Division of Public Health

RE: Food Lion #595
8 The Square at Lillington
Lillington, NC 27546

This letter acknowledges review of the remodel plan for the above referenced establishment. The plans received on 07/26/2023 application, and specifications including email correspondence are approved with the following comments:

7 OF 35
A1.01
 REVISED EQUIPMENT PLAN

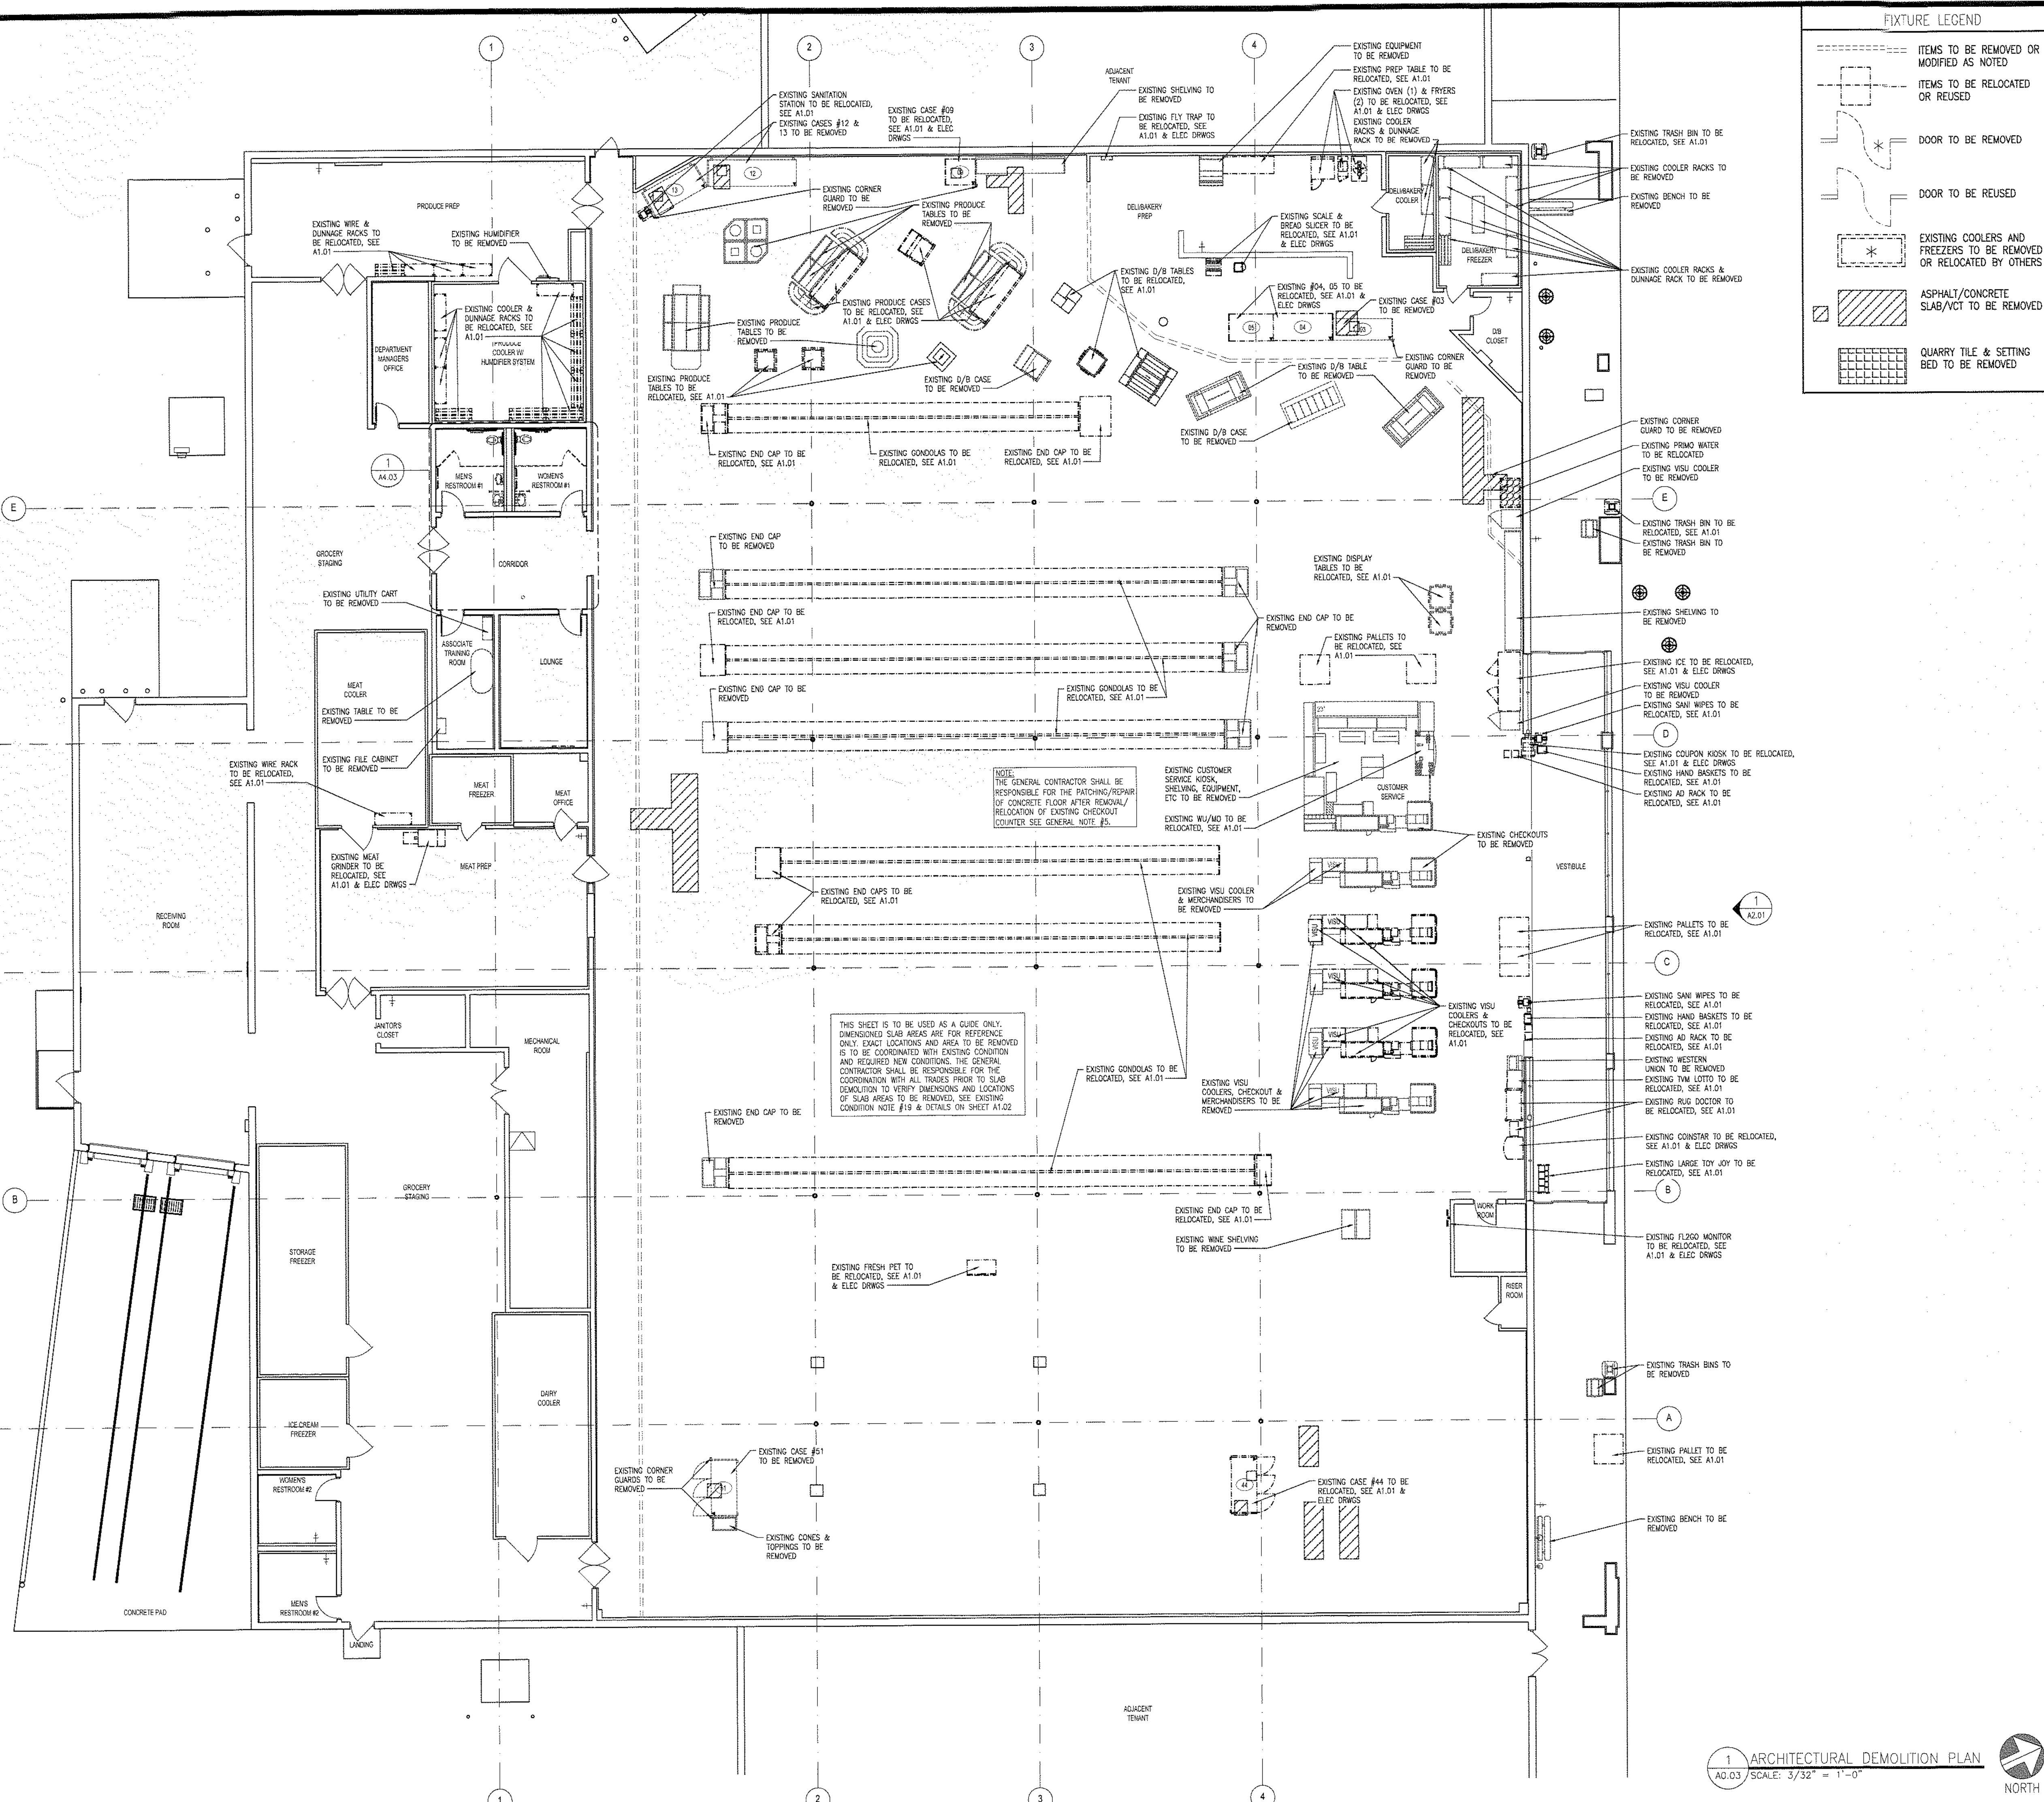
2. Updated food equipment must comply with Section 4-205.10 of the North Carolina Food Code and be installed as specified in Sections 4-402.11 and 4-402.12. The grinder in the Meat Department will be relocated from the existing Meat Prep area, into the Meat Department's walk-in cooler.(see 2a) All other existing equipment, and fixtures remain approved, and with this understanding; the revised fixture plan is approved.

- 2a. It is understood with the relocation of the meat grinder to the meat walk-in cooler, the door to the walk-in cooler must remain open during grinding operations for employees to travel to the existing Meat Department handsink to properly wash hands. The door remains open to eliminate any touchable surfaces which could contaminate and re-contaminate hands. Per your Department Review Letter, it is understood that as a procedural standard the meat cooler room door will remain open during operations. It is also understood that an approved light fixture will be installed above the grinder to meet lighting requirements.

1 ENLARGED DELI/BAKERY EQUIPMENT PLAN
A4.01 SCALE: 1/4" = 1'-0"

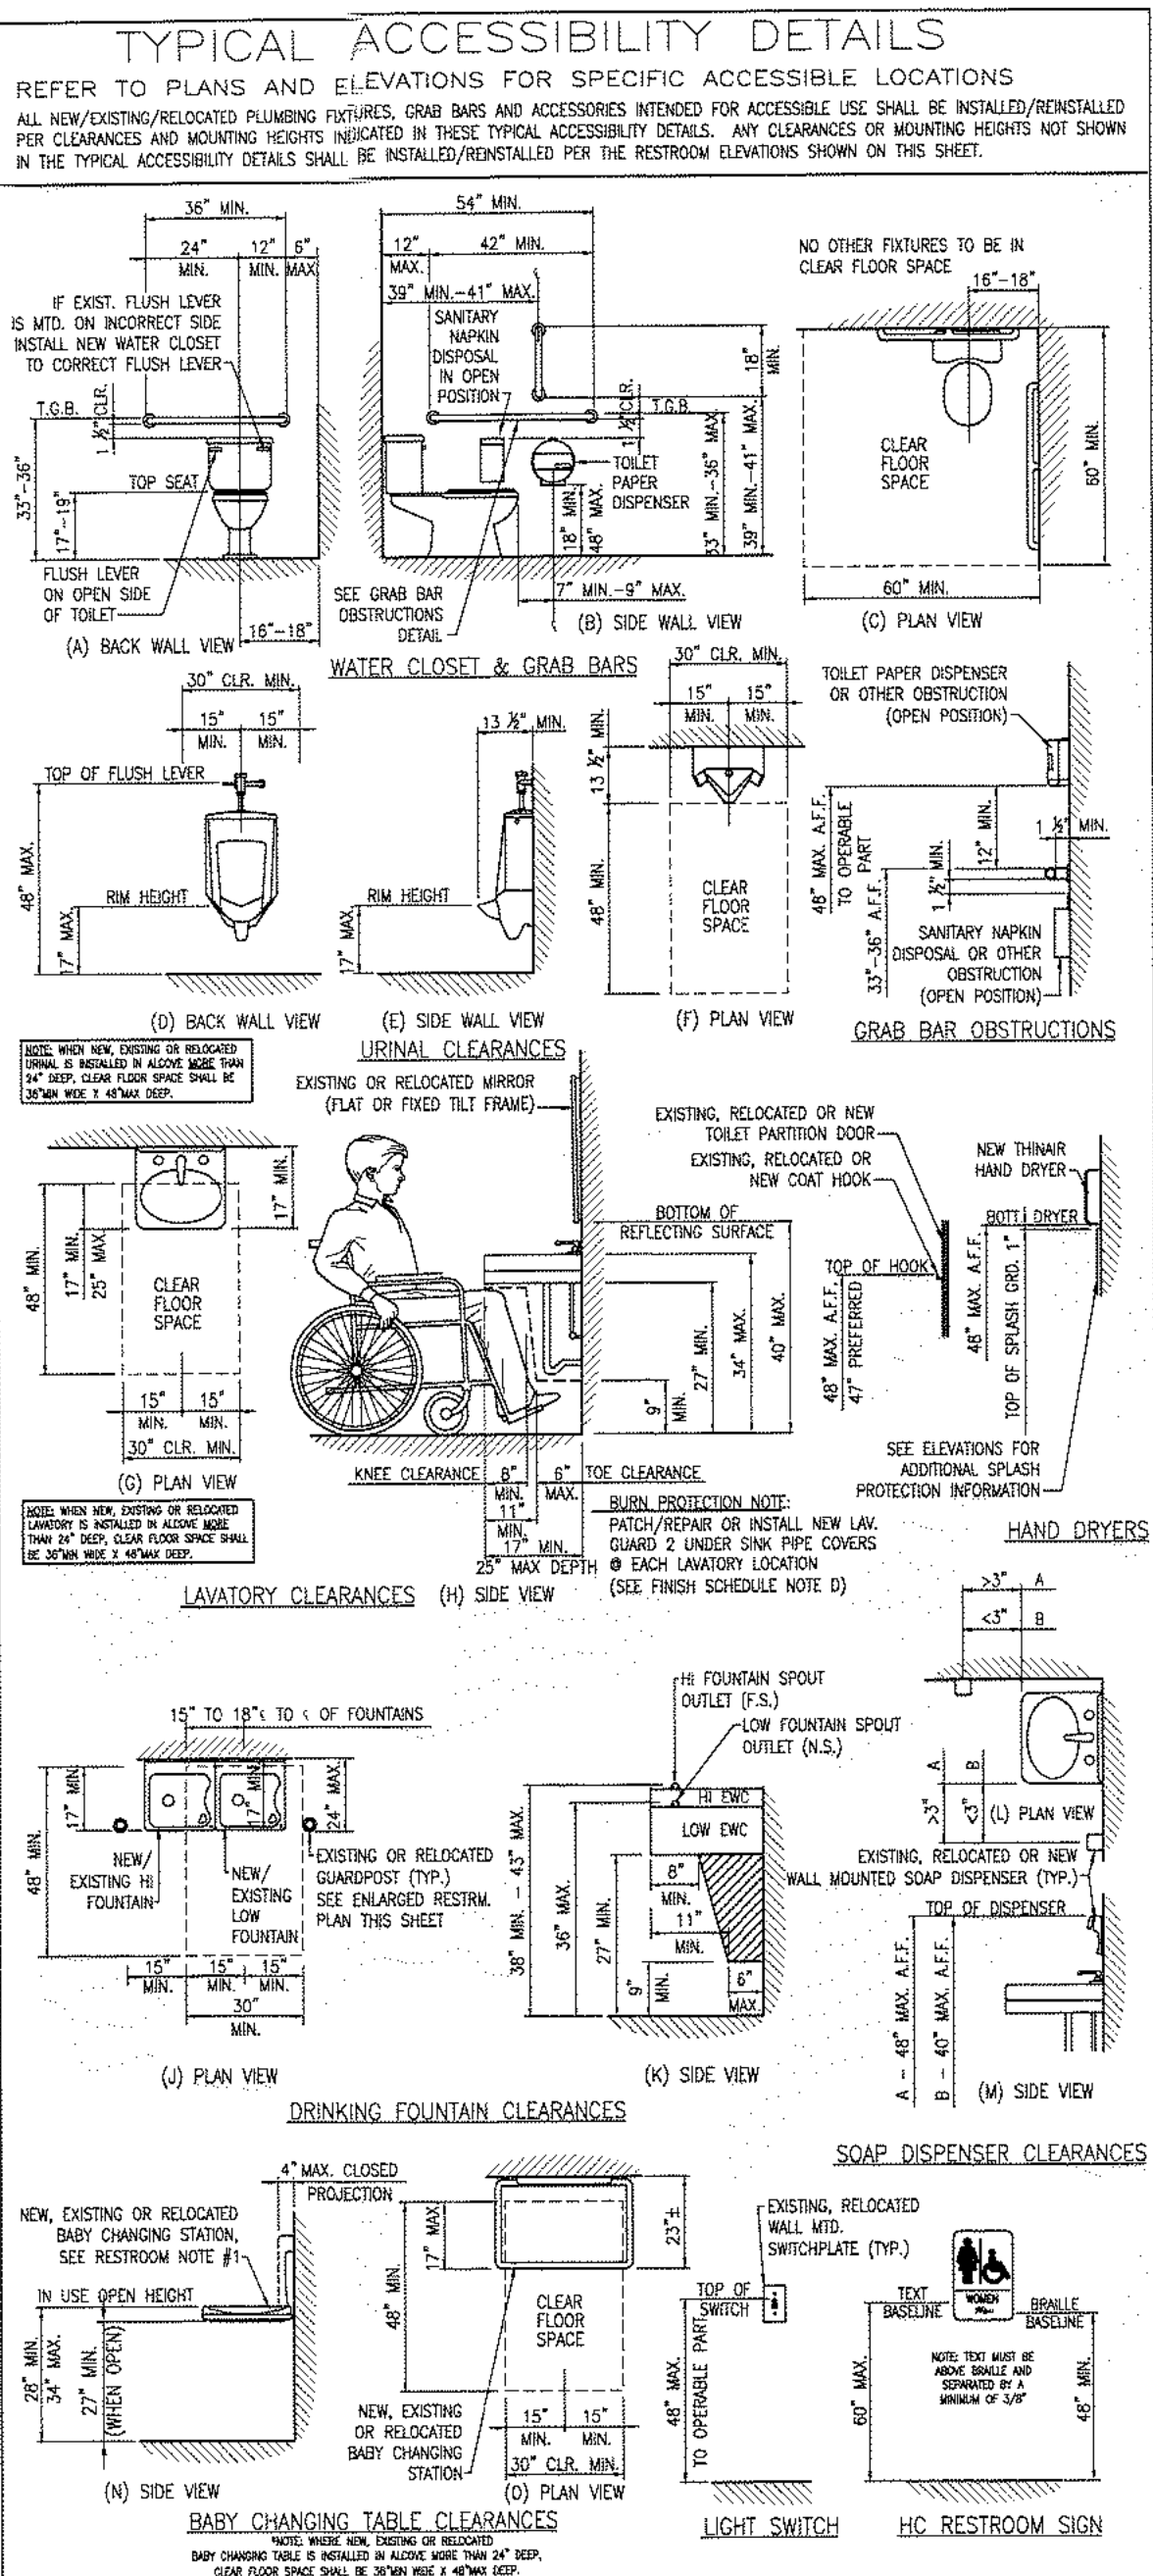
1. The scope of work covers the addition of new equipment in the Deli/Bakery Prep/Sales Areas with the installation of a new equipment including: (1) hot wing bar (1) hot deli case (3) boat racks (12) cooler racks (1) scale (1) stainless steel table and (2) café doors. The existing combi-oven (and relocated fryer/s) will need to remain installed under the hood in accordance with local building code, as well as meeting all requirements in the equipment specification sheet. In addition, listed existing equipment will be relocated as part of the remodel as indicated in the supplied SCOPE of Work. Please note, this conditioned approval does not include future or added equipment that was not supplied with this scope of work.

1 WATER PIPING PLAN
P1.03 SCALE: 3/32" = 1'-0"
NORTH

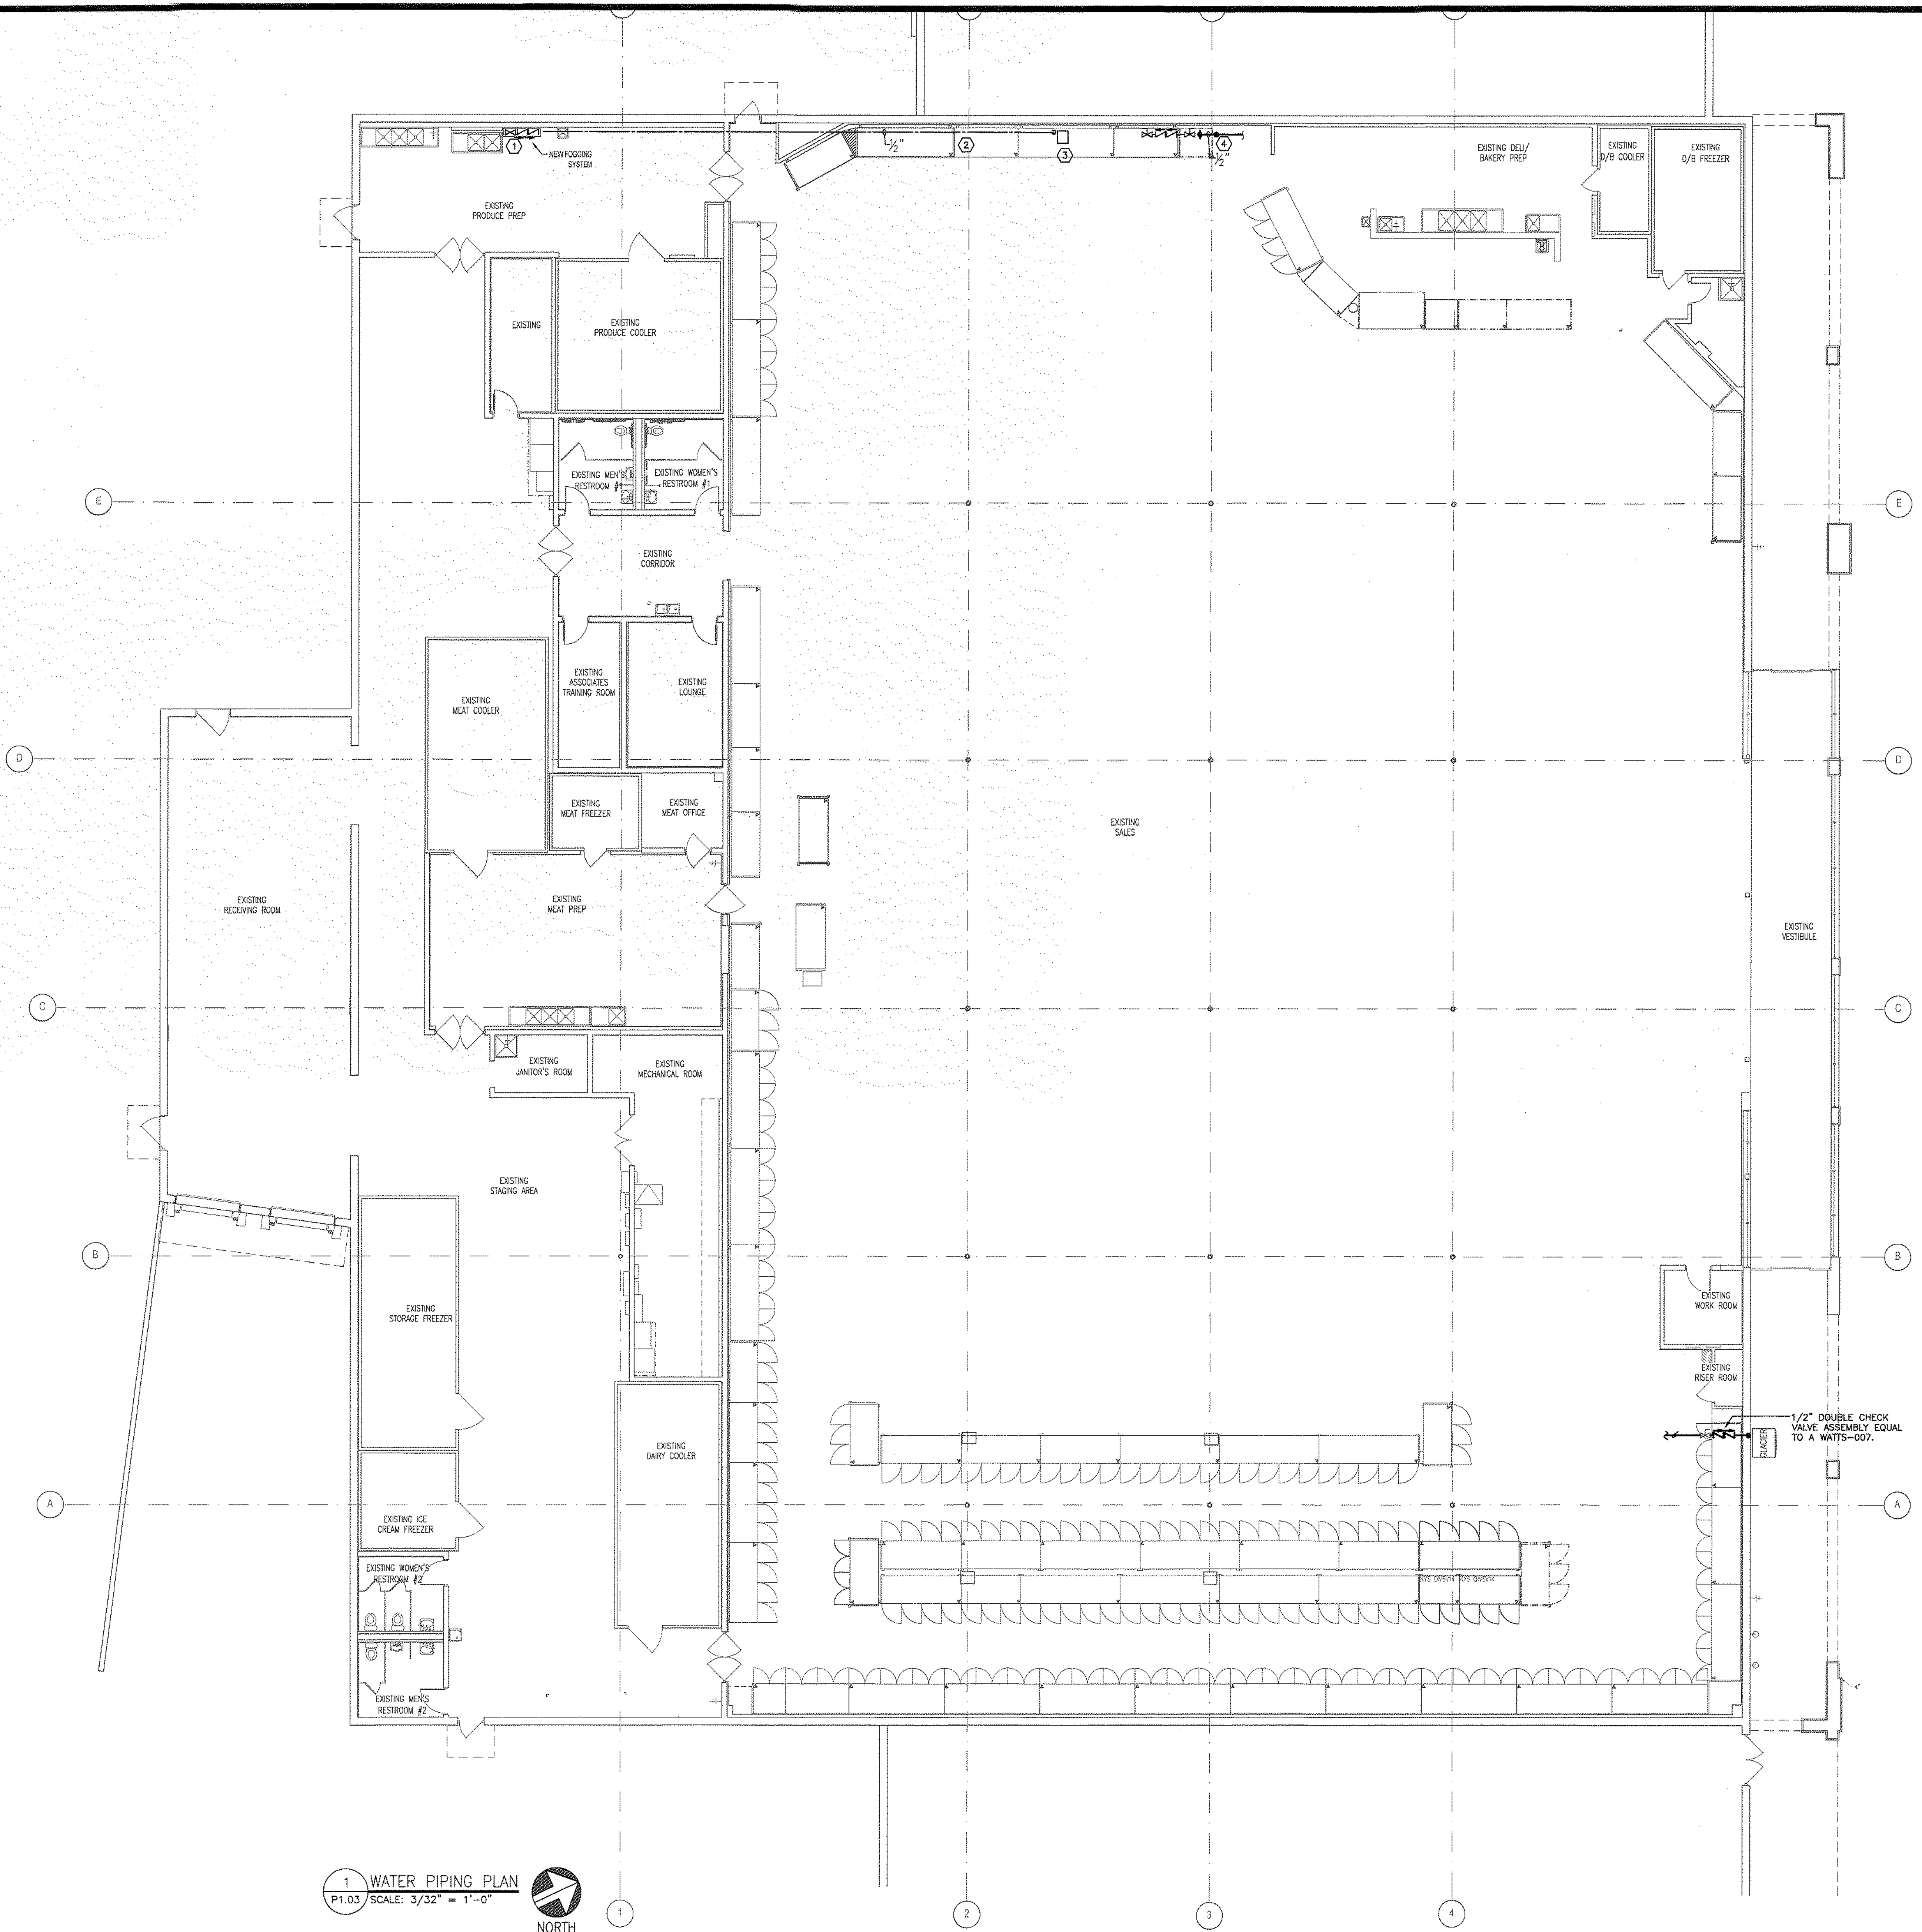
4. The existing Sanitary Sewer and Water Piping plans are approved for continuous use. The hot water heating system supplied as specified is also approved for continuous use. The existing water heating system is acceptable if it is sufficient to meet peak hot water demands. If it does not, the hot water system will be modified, and/or replaced to meet hot water requirements.
